April 2, 2009

Dan Valoff, Staff Planner
Community Development Services
411 N Ruby Street, Suite 2
Ellensburg, WA 98926

Thank you for the opportunity to comment on the Graybill Short Plat, SP-09-00006. Pursuant to the Memorandum of Agreement between Kittitas County and the Washington State Department of Ecology all residential well connections serving the proposed lots shall be required to have meters installed. Metering results shall be recorded in a manner consistent with Kittitas County and Washington State Department of Ecology requirements. The requirement to meter only applies if you rely upon the RCW 90.44.050 exemption from permitting through ecology.

GRAYBILL SHORT PLAT
PART OF SECTION 34, T. 17 N., R. 19 E., W.M.
KITTITAS COUNTY, WASHINGTON

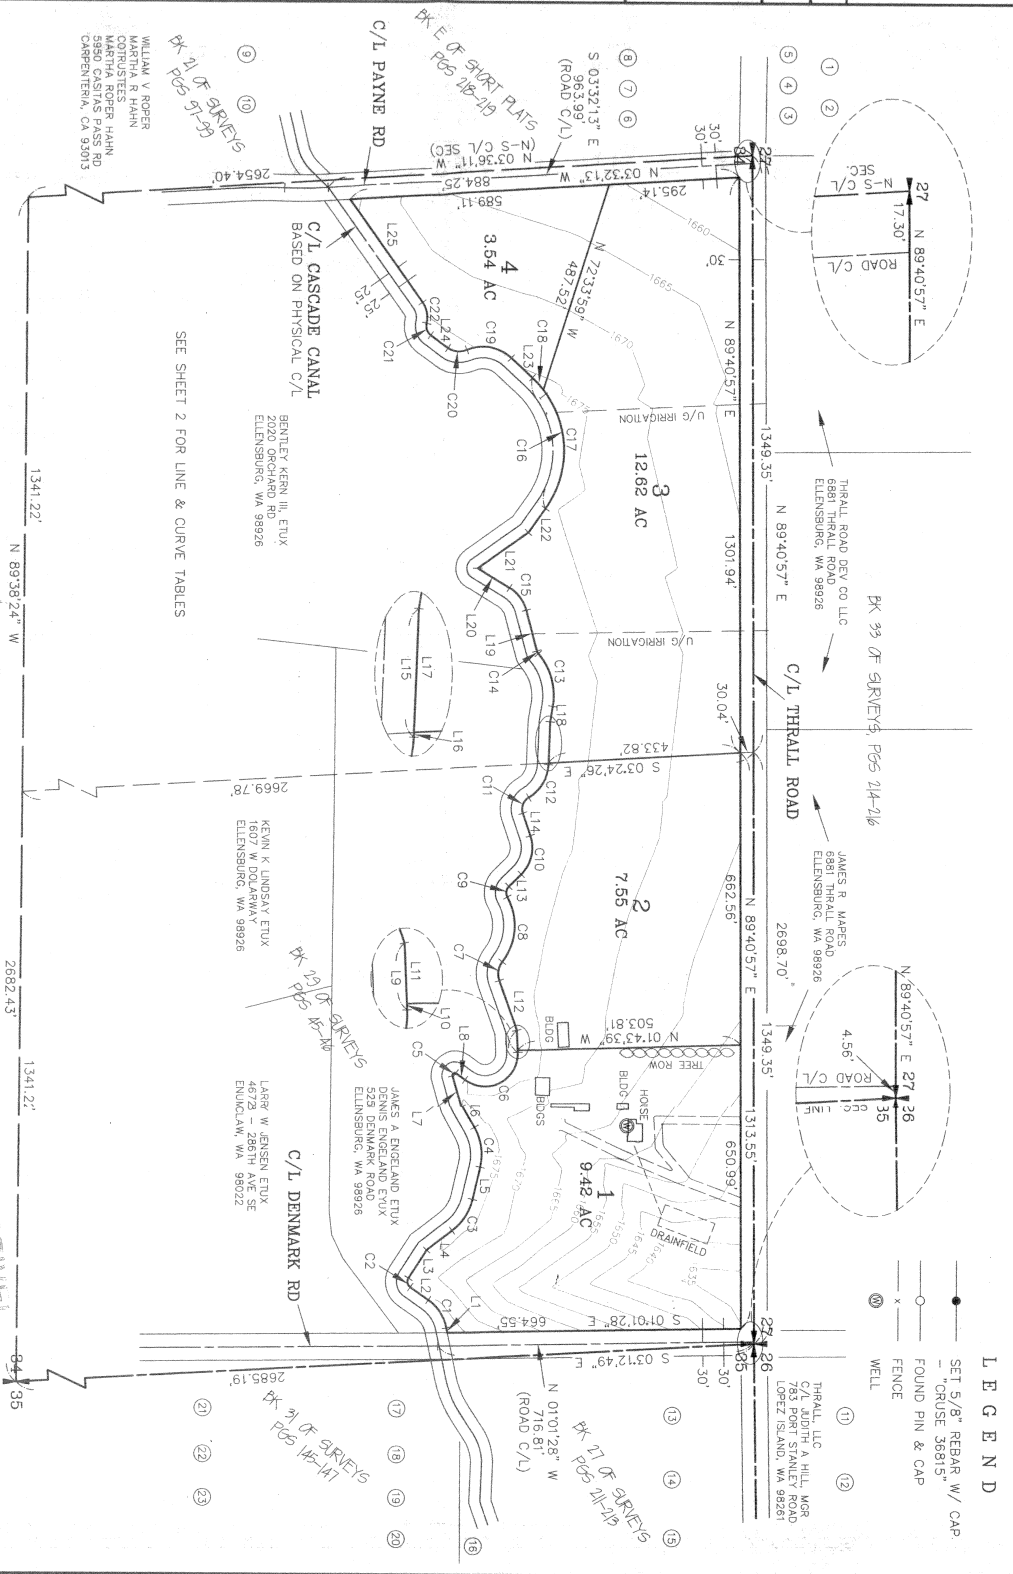
The final plat notes shall include the following two statements:

"The approval of this division of land includes no guarantee that there is a legal right to withdraw groundwater within the land division. The approval of this division of land provides no guarantee that use of water under the ground water exemption (RCW 90.44.050) for this plat or any portion thereof will not be subject to curtailment by the Department of Ecology or a court of law. "

"Metering will be required on all new residential well connections and metering results shall be recorded in a manner consistent with Kittitas County and Washington State Department of Ecology requirements."

The Public Health Department's recommendation shall state that final approval be conditioned upon the developer/owner of the plat providing proof of water availability. Water availability can be provided through several different ways depending on the source of water proposed.

If individual wells are proposed for the parcels and there is an existing well located on the plat, a well log from Washington State Department of Ecology will meet the water availability requirement. If there is not an existing well on the plat, then a **water availability report** with documentation and evidence to support the claim regarding adequate availability of groundwater for the proposed number of potable water wells must be submitted for review.

At this time the application does not contain sufficient information to make a determination of adequate water availability or soil assessment to determine the land area is suitable for onsite sewage systems. The above mentioned items need to be submitted to the Public Health Department in order for the plat application to be recommended for approval.
